From: Matthew Driver [REDACTED]
Sent: 19 October 2017 15:42
To: Michael Eastham
Cc: Paul Cann; Sue Howell; 'Stephen Gee'; [REDACTED]
Subject: RE: BN/28/17/RES - Application for Reserved Matters - The Lillies, Yapton Road, Barnham

Subject: BN/28/17/RES - Application for Reserved Matters - The Lillies, Yapton Road, Barnham

BN/28/17/RES - Application for the approval of Reserved Matters - The Lillies, Yapton Road, Barnham

scheme: The Lillies, Yapton Rd
Barnham
client: Matthew Homes
drawing: Landscape Proposals
date: April 2017
scale: 1:200@A1
drawing no: MAT21212 11A sheet 1
drawn: AE checked: DKM

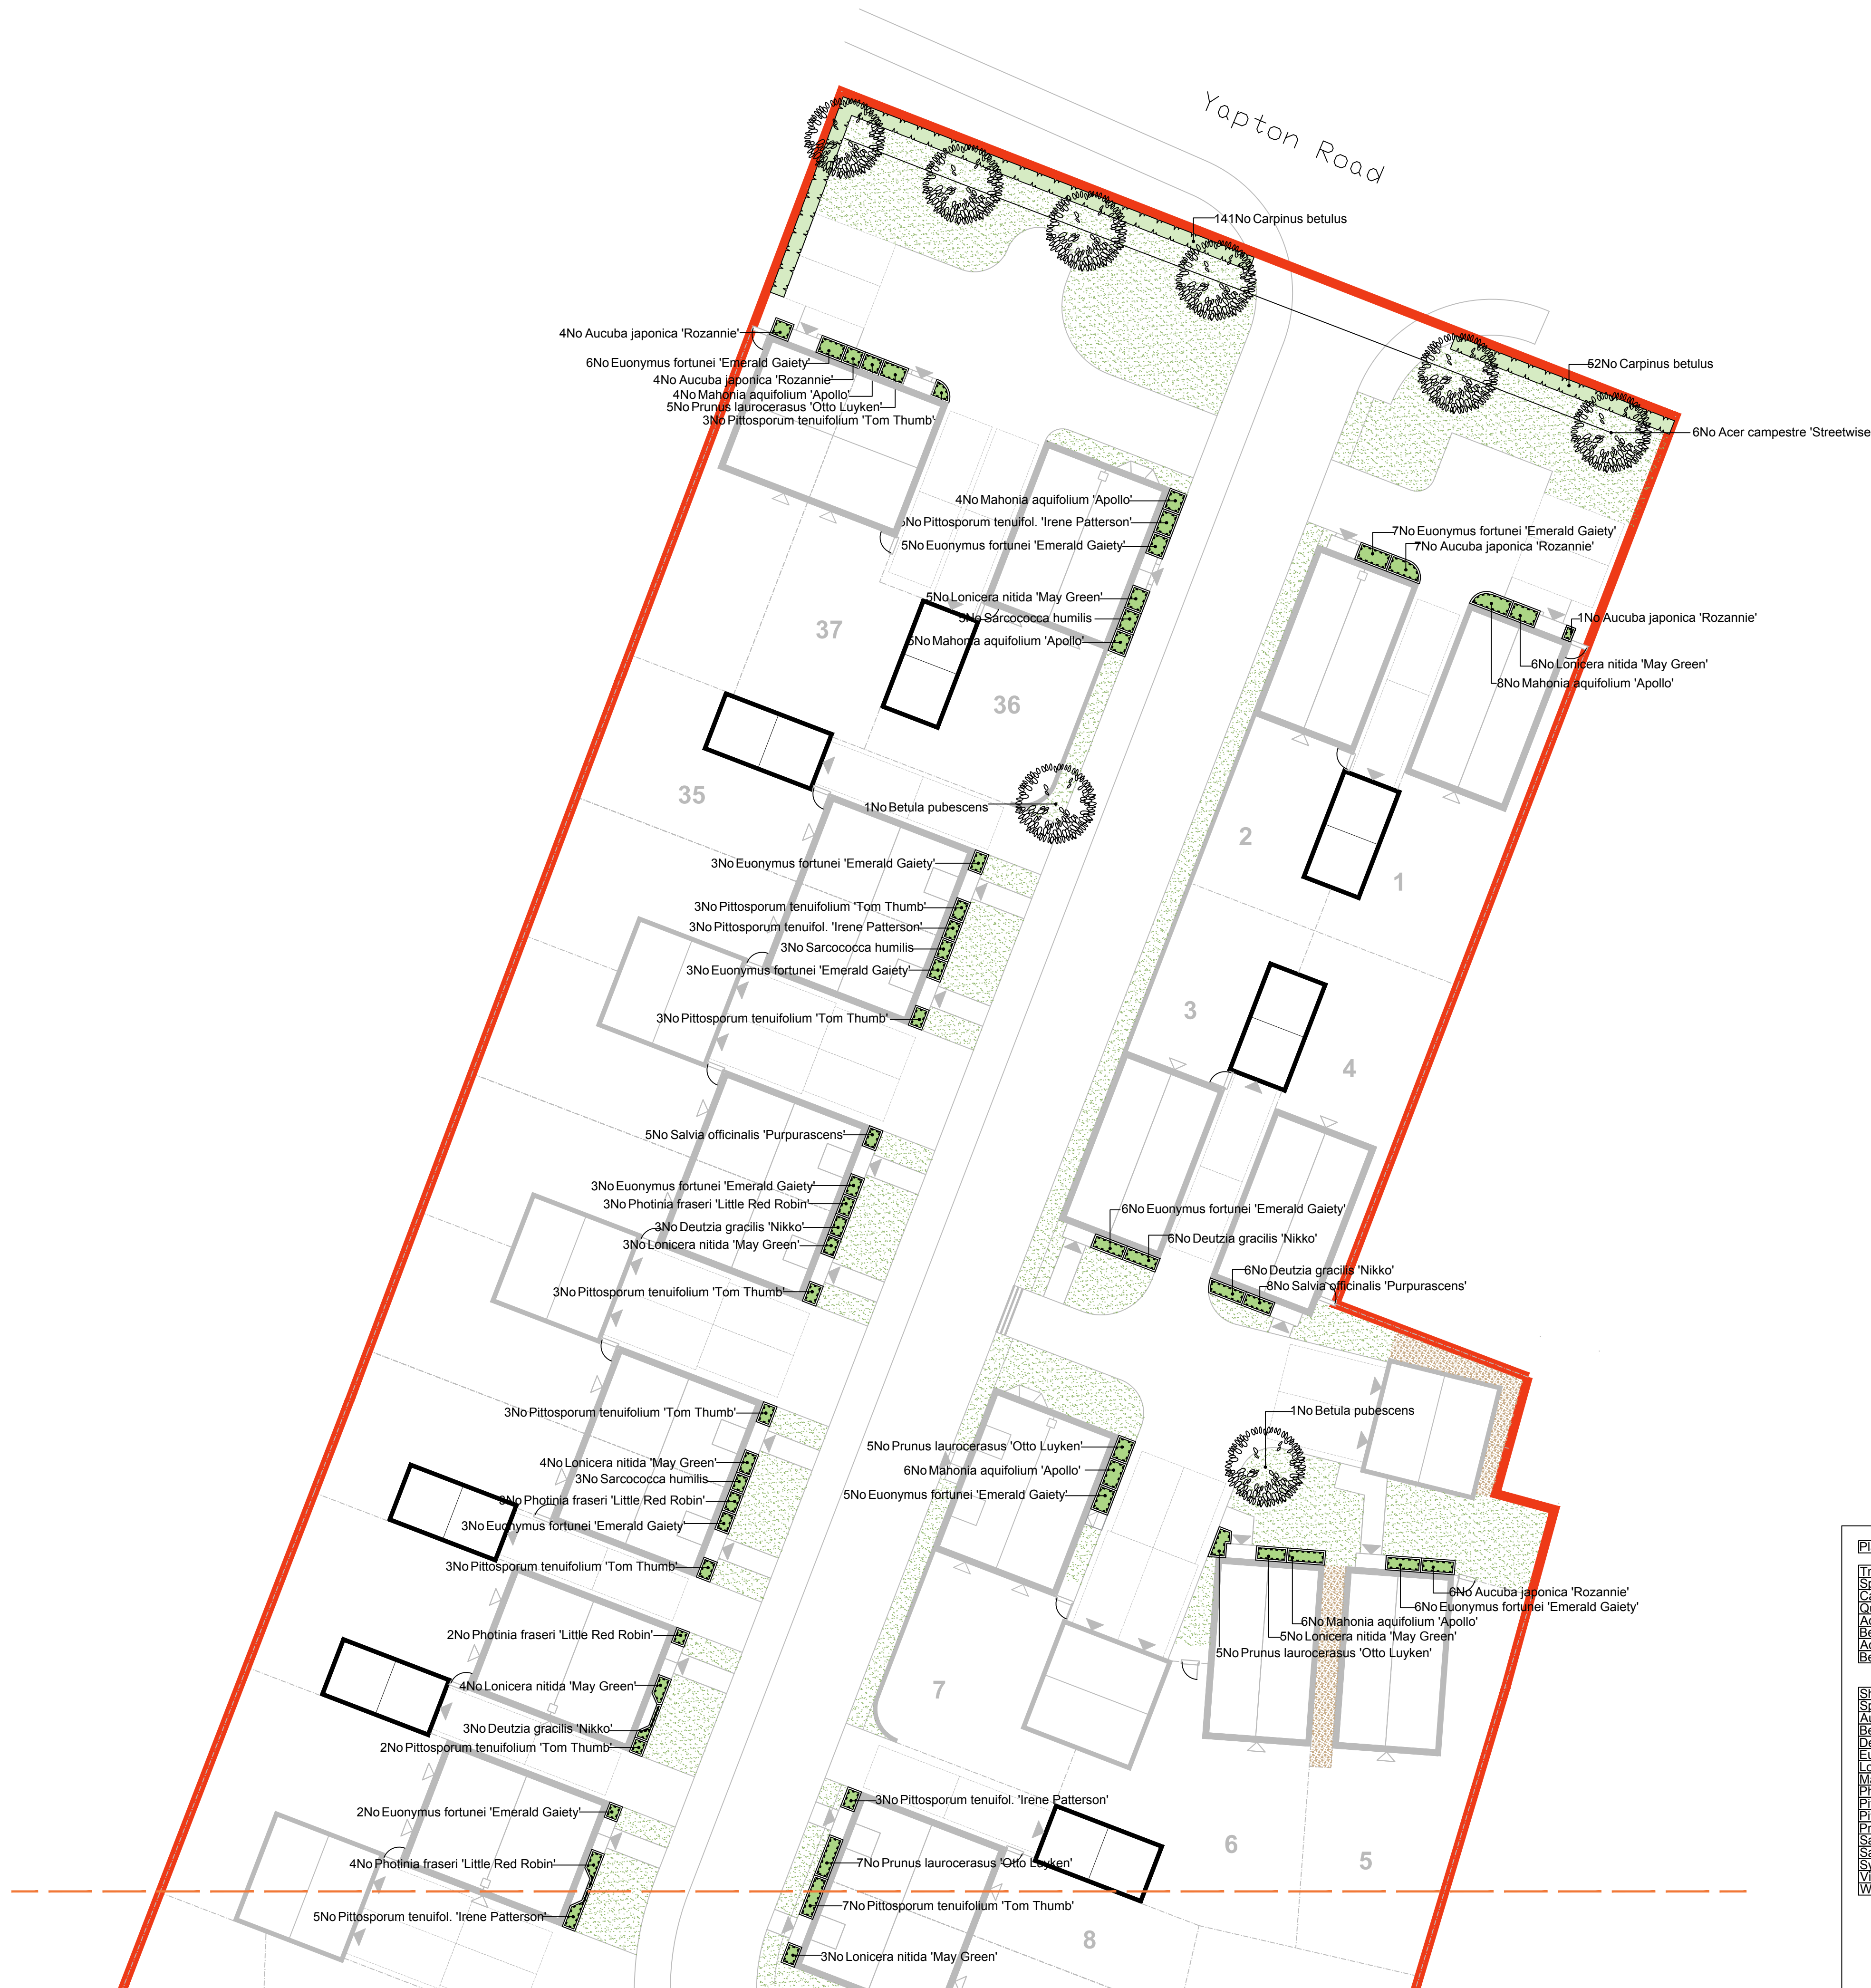
- 1) The site access details (i.e. visibility splays and sightlines) requested by the Local Highway Authority (WSCC). I understand that Dominic Smith dealt with the consultation initially on 25th August 2017 and requested more information. Stephen Gee is the current case officer at WSCC and he is awaiting the requisite plans. – Plan attached
- 2) The requisite drainage details so that the ADC Drainage Engineer, Paul Cann, may sign off the drainage conditions which were imposed on the outline planning permission. – Revised drainage details have already been submitted.
- 3) It was recommended at pre-application stage and again in an email sent by me on 16th August 2017 that the flatted building (the apartment block) be shown with some curtilage/defensible space particularly on the rear

elevation which backs onto the POS. This has not been shown. The current arrangement would allow users of the POS to get right up to the ground floor windows. – Please check the updated plans as both the coloured site layout and landscaping plans show hedging to the rear of the flat block thus creating defensible space.
